Our R/2020/7/C
reference:

Your SSD 10438 MOD 1
reference:

Subject: Advice on Modification - Waterloo Metro Quarter OSD - Northern and Central Precinct
Basement - SSD 10438 MOD 1

Sheet title
SSD10438
BASEMENT - FLOOR PLAN LEVEL P1

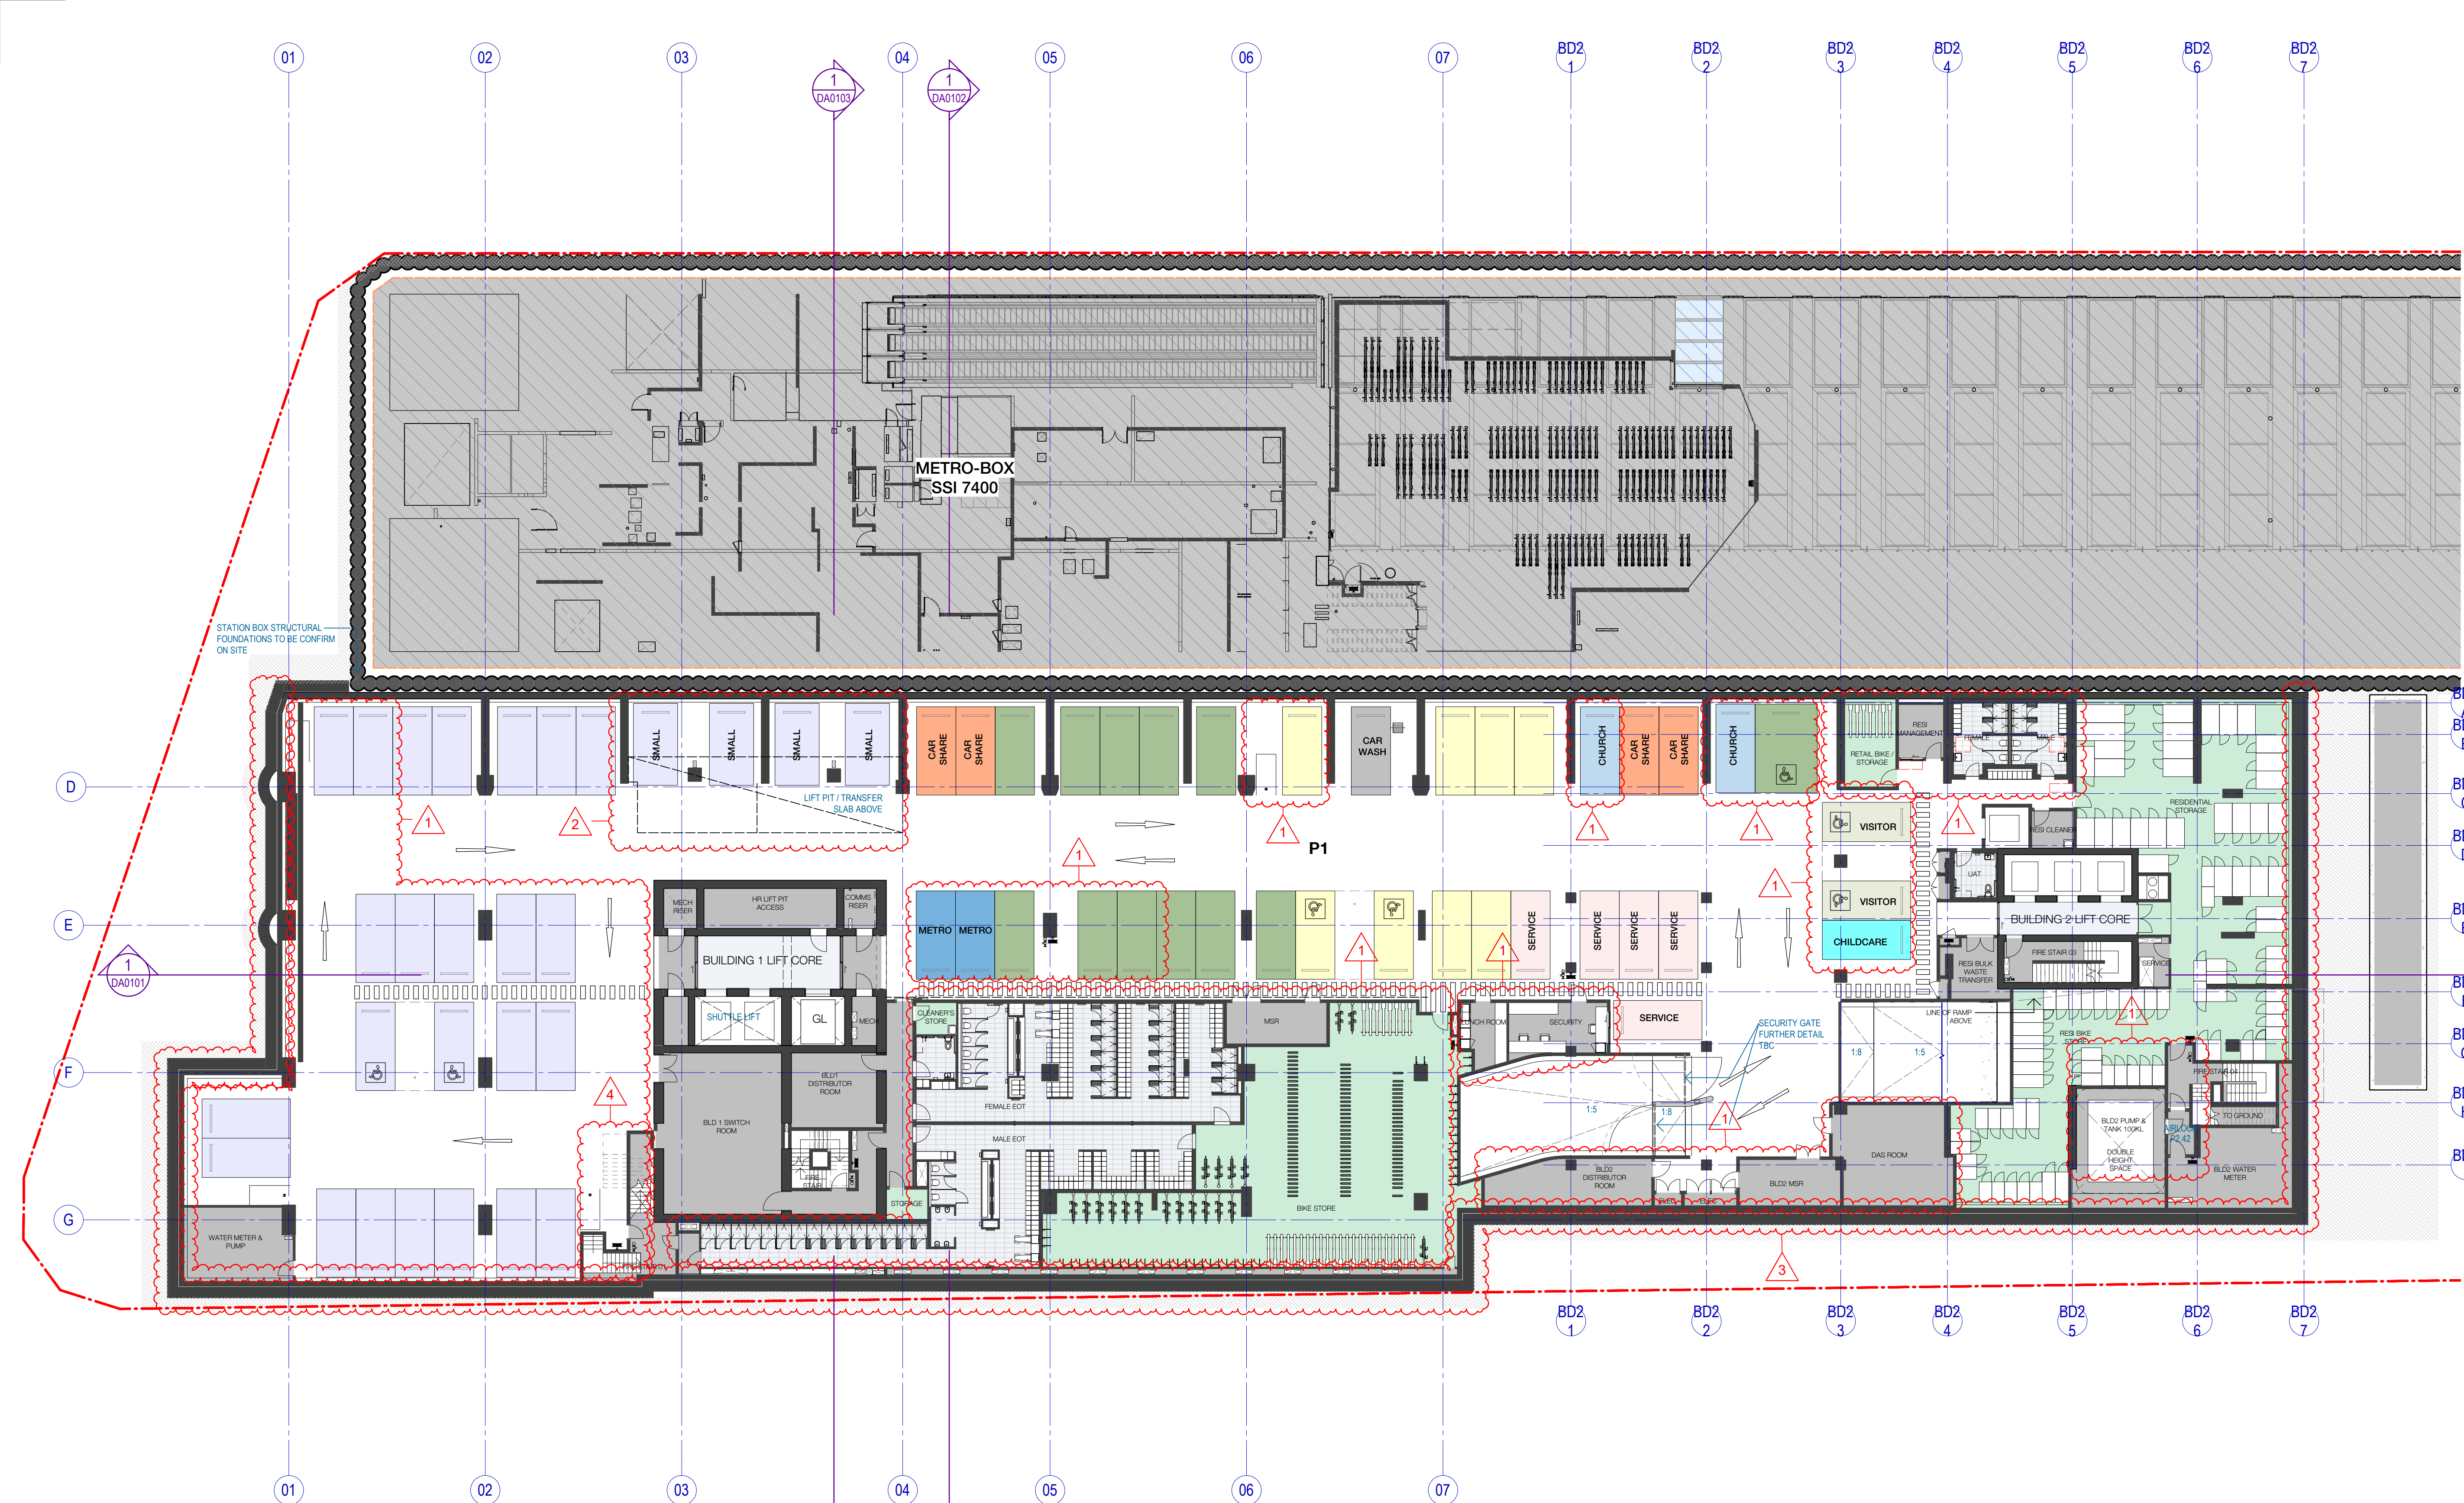
The removal of blind parking aisles in favour of a one-way circulation system in the northern end of levels B1 and B2 is supported. This will reduce conflicts and the complex manoeuvres required to exit some spaces. Additionally, the consolidation of residential parking into one location is noted and supported.

Further, the new location of the end of journey and bike parking is now midway between the two lift cores rather than closer to the northern core, which makes bike access to both buildings similar. This new location is supported, noting that wayfinding will be required to help users orientate themselves.
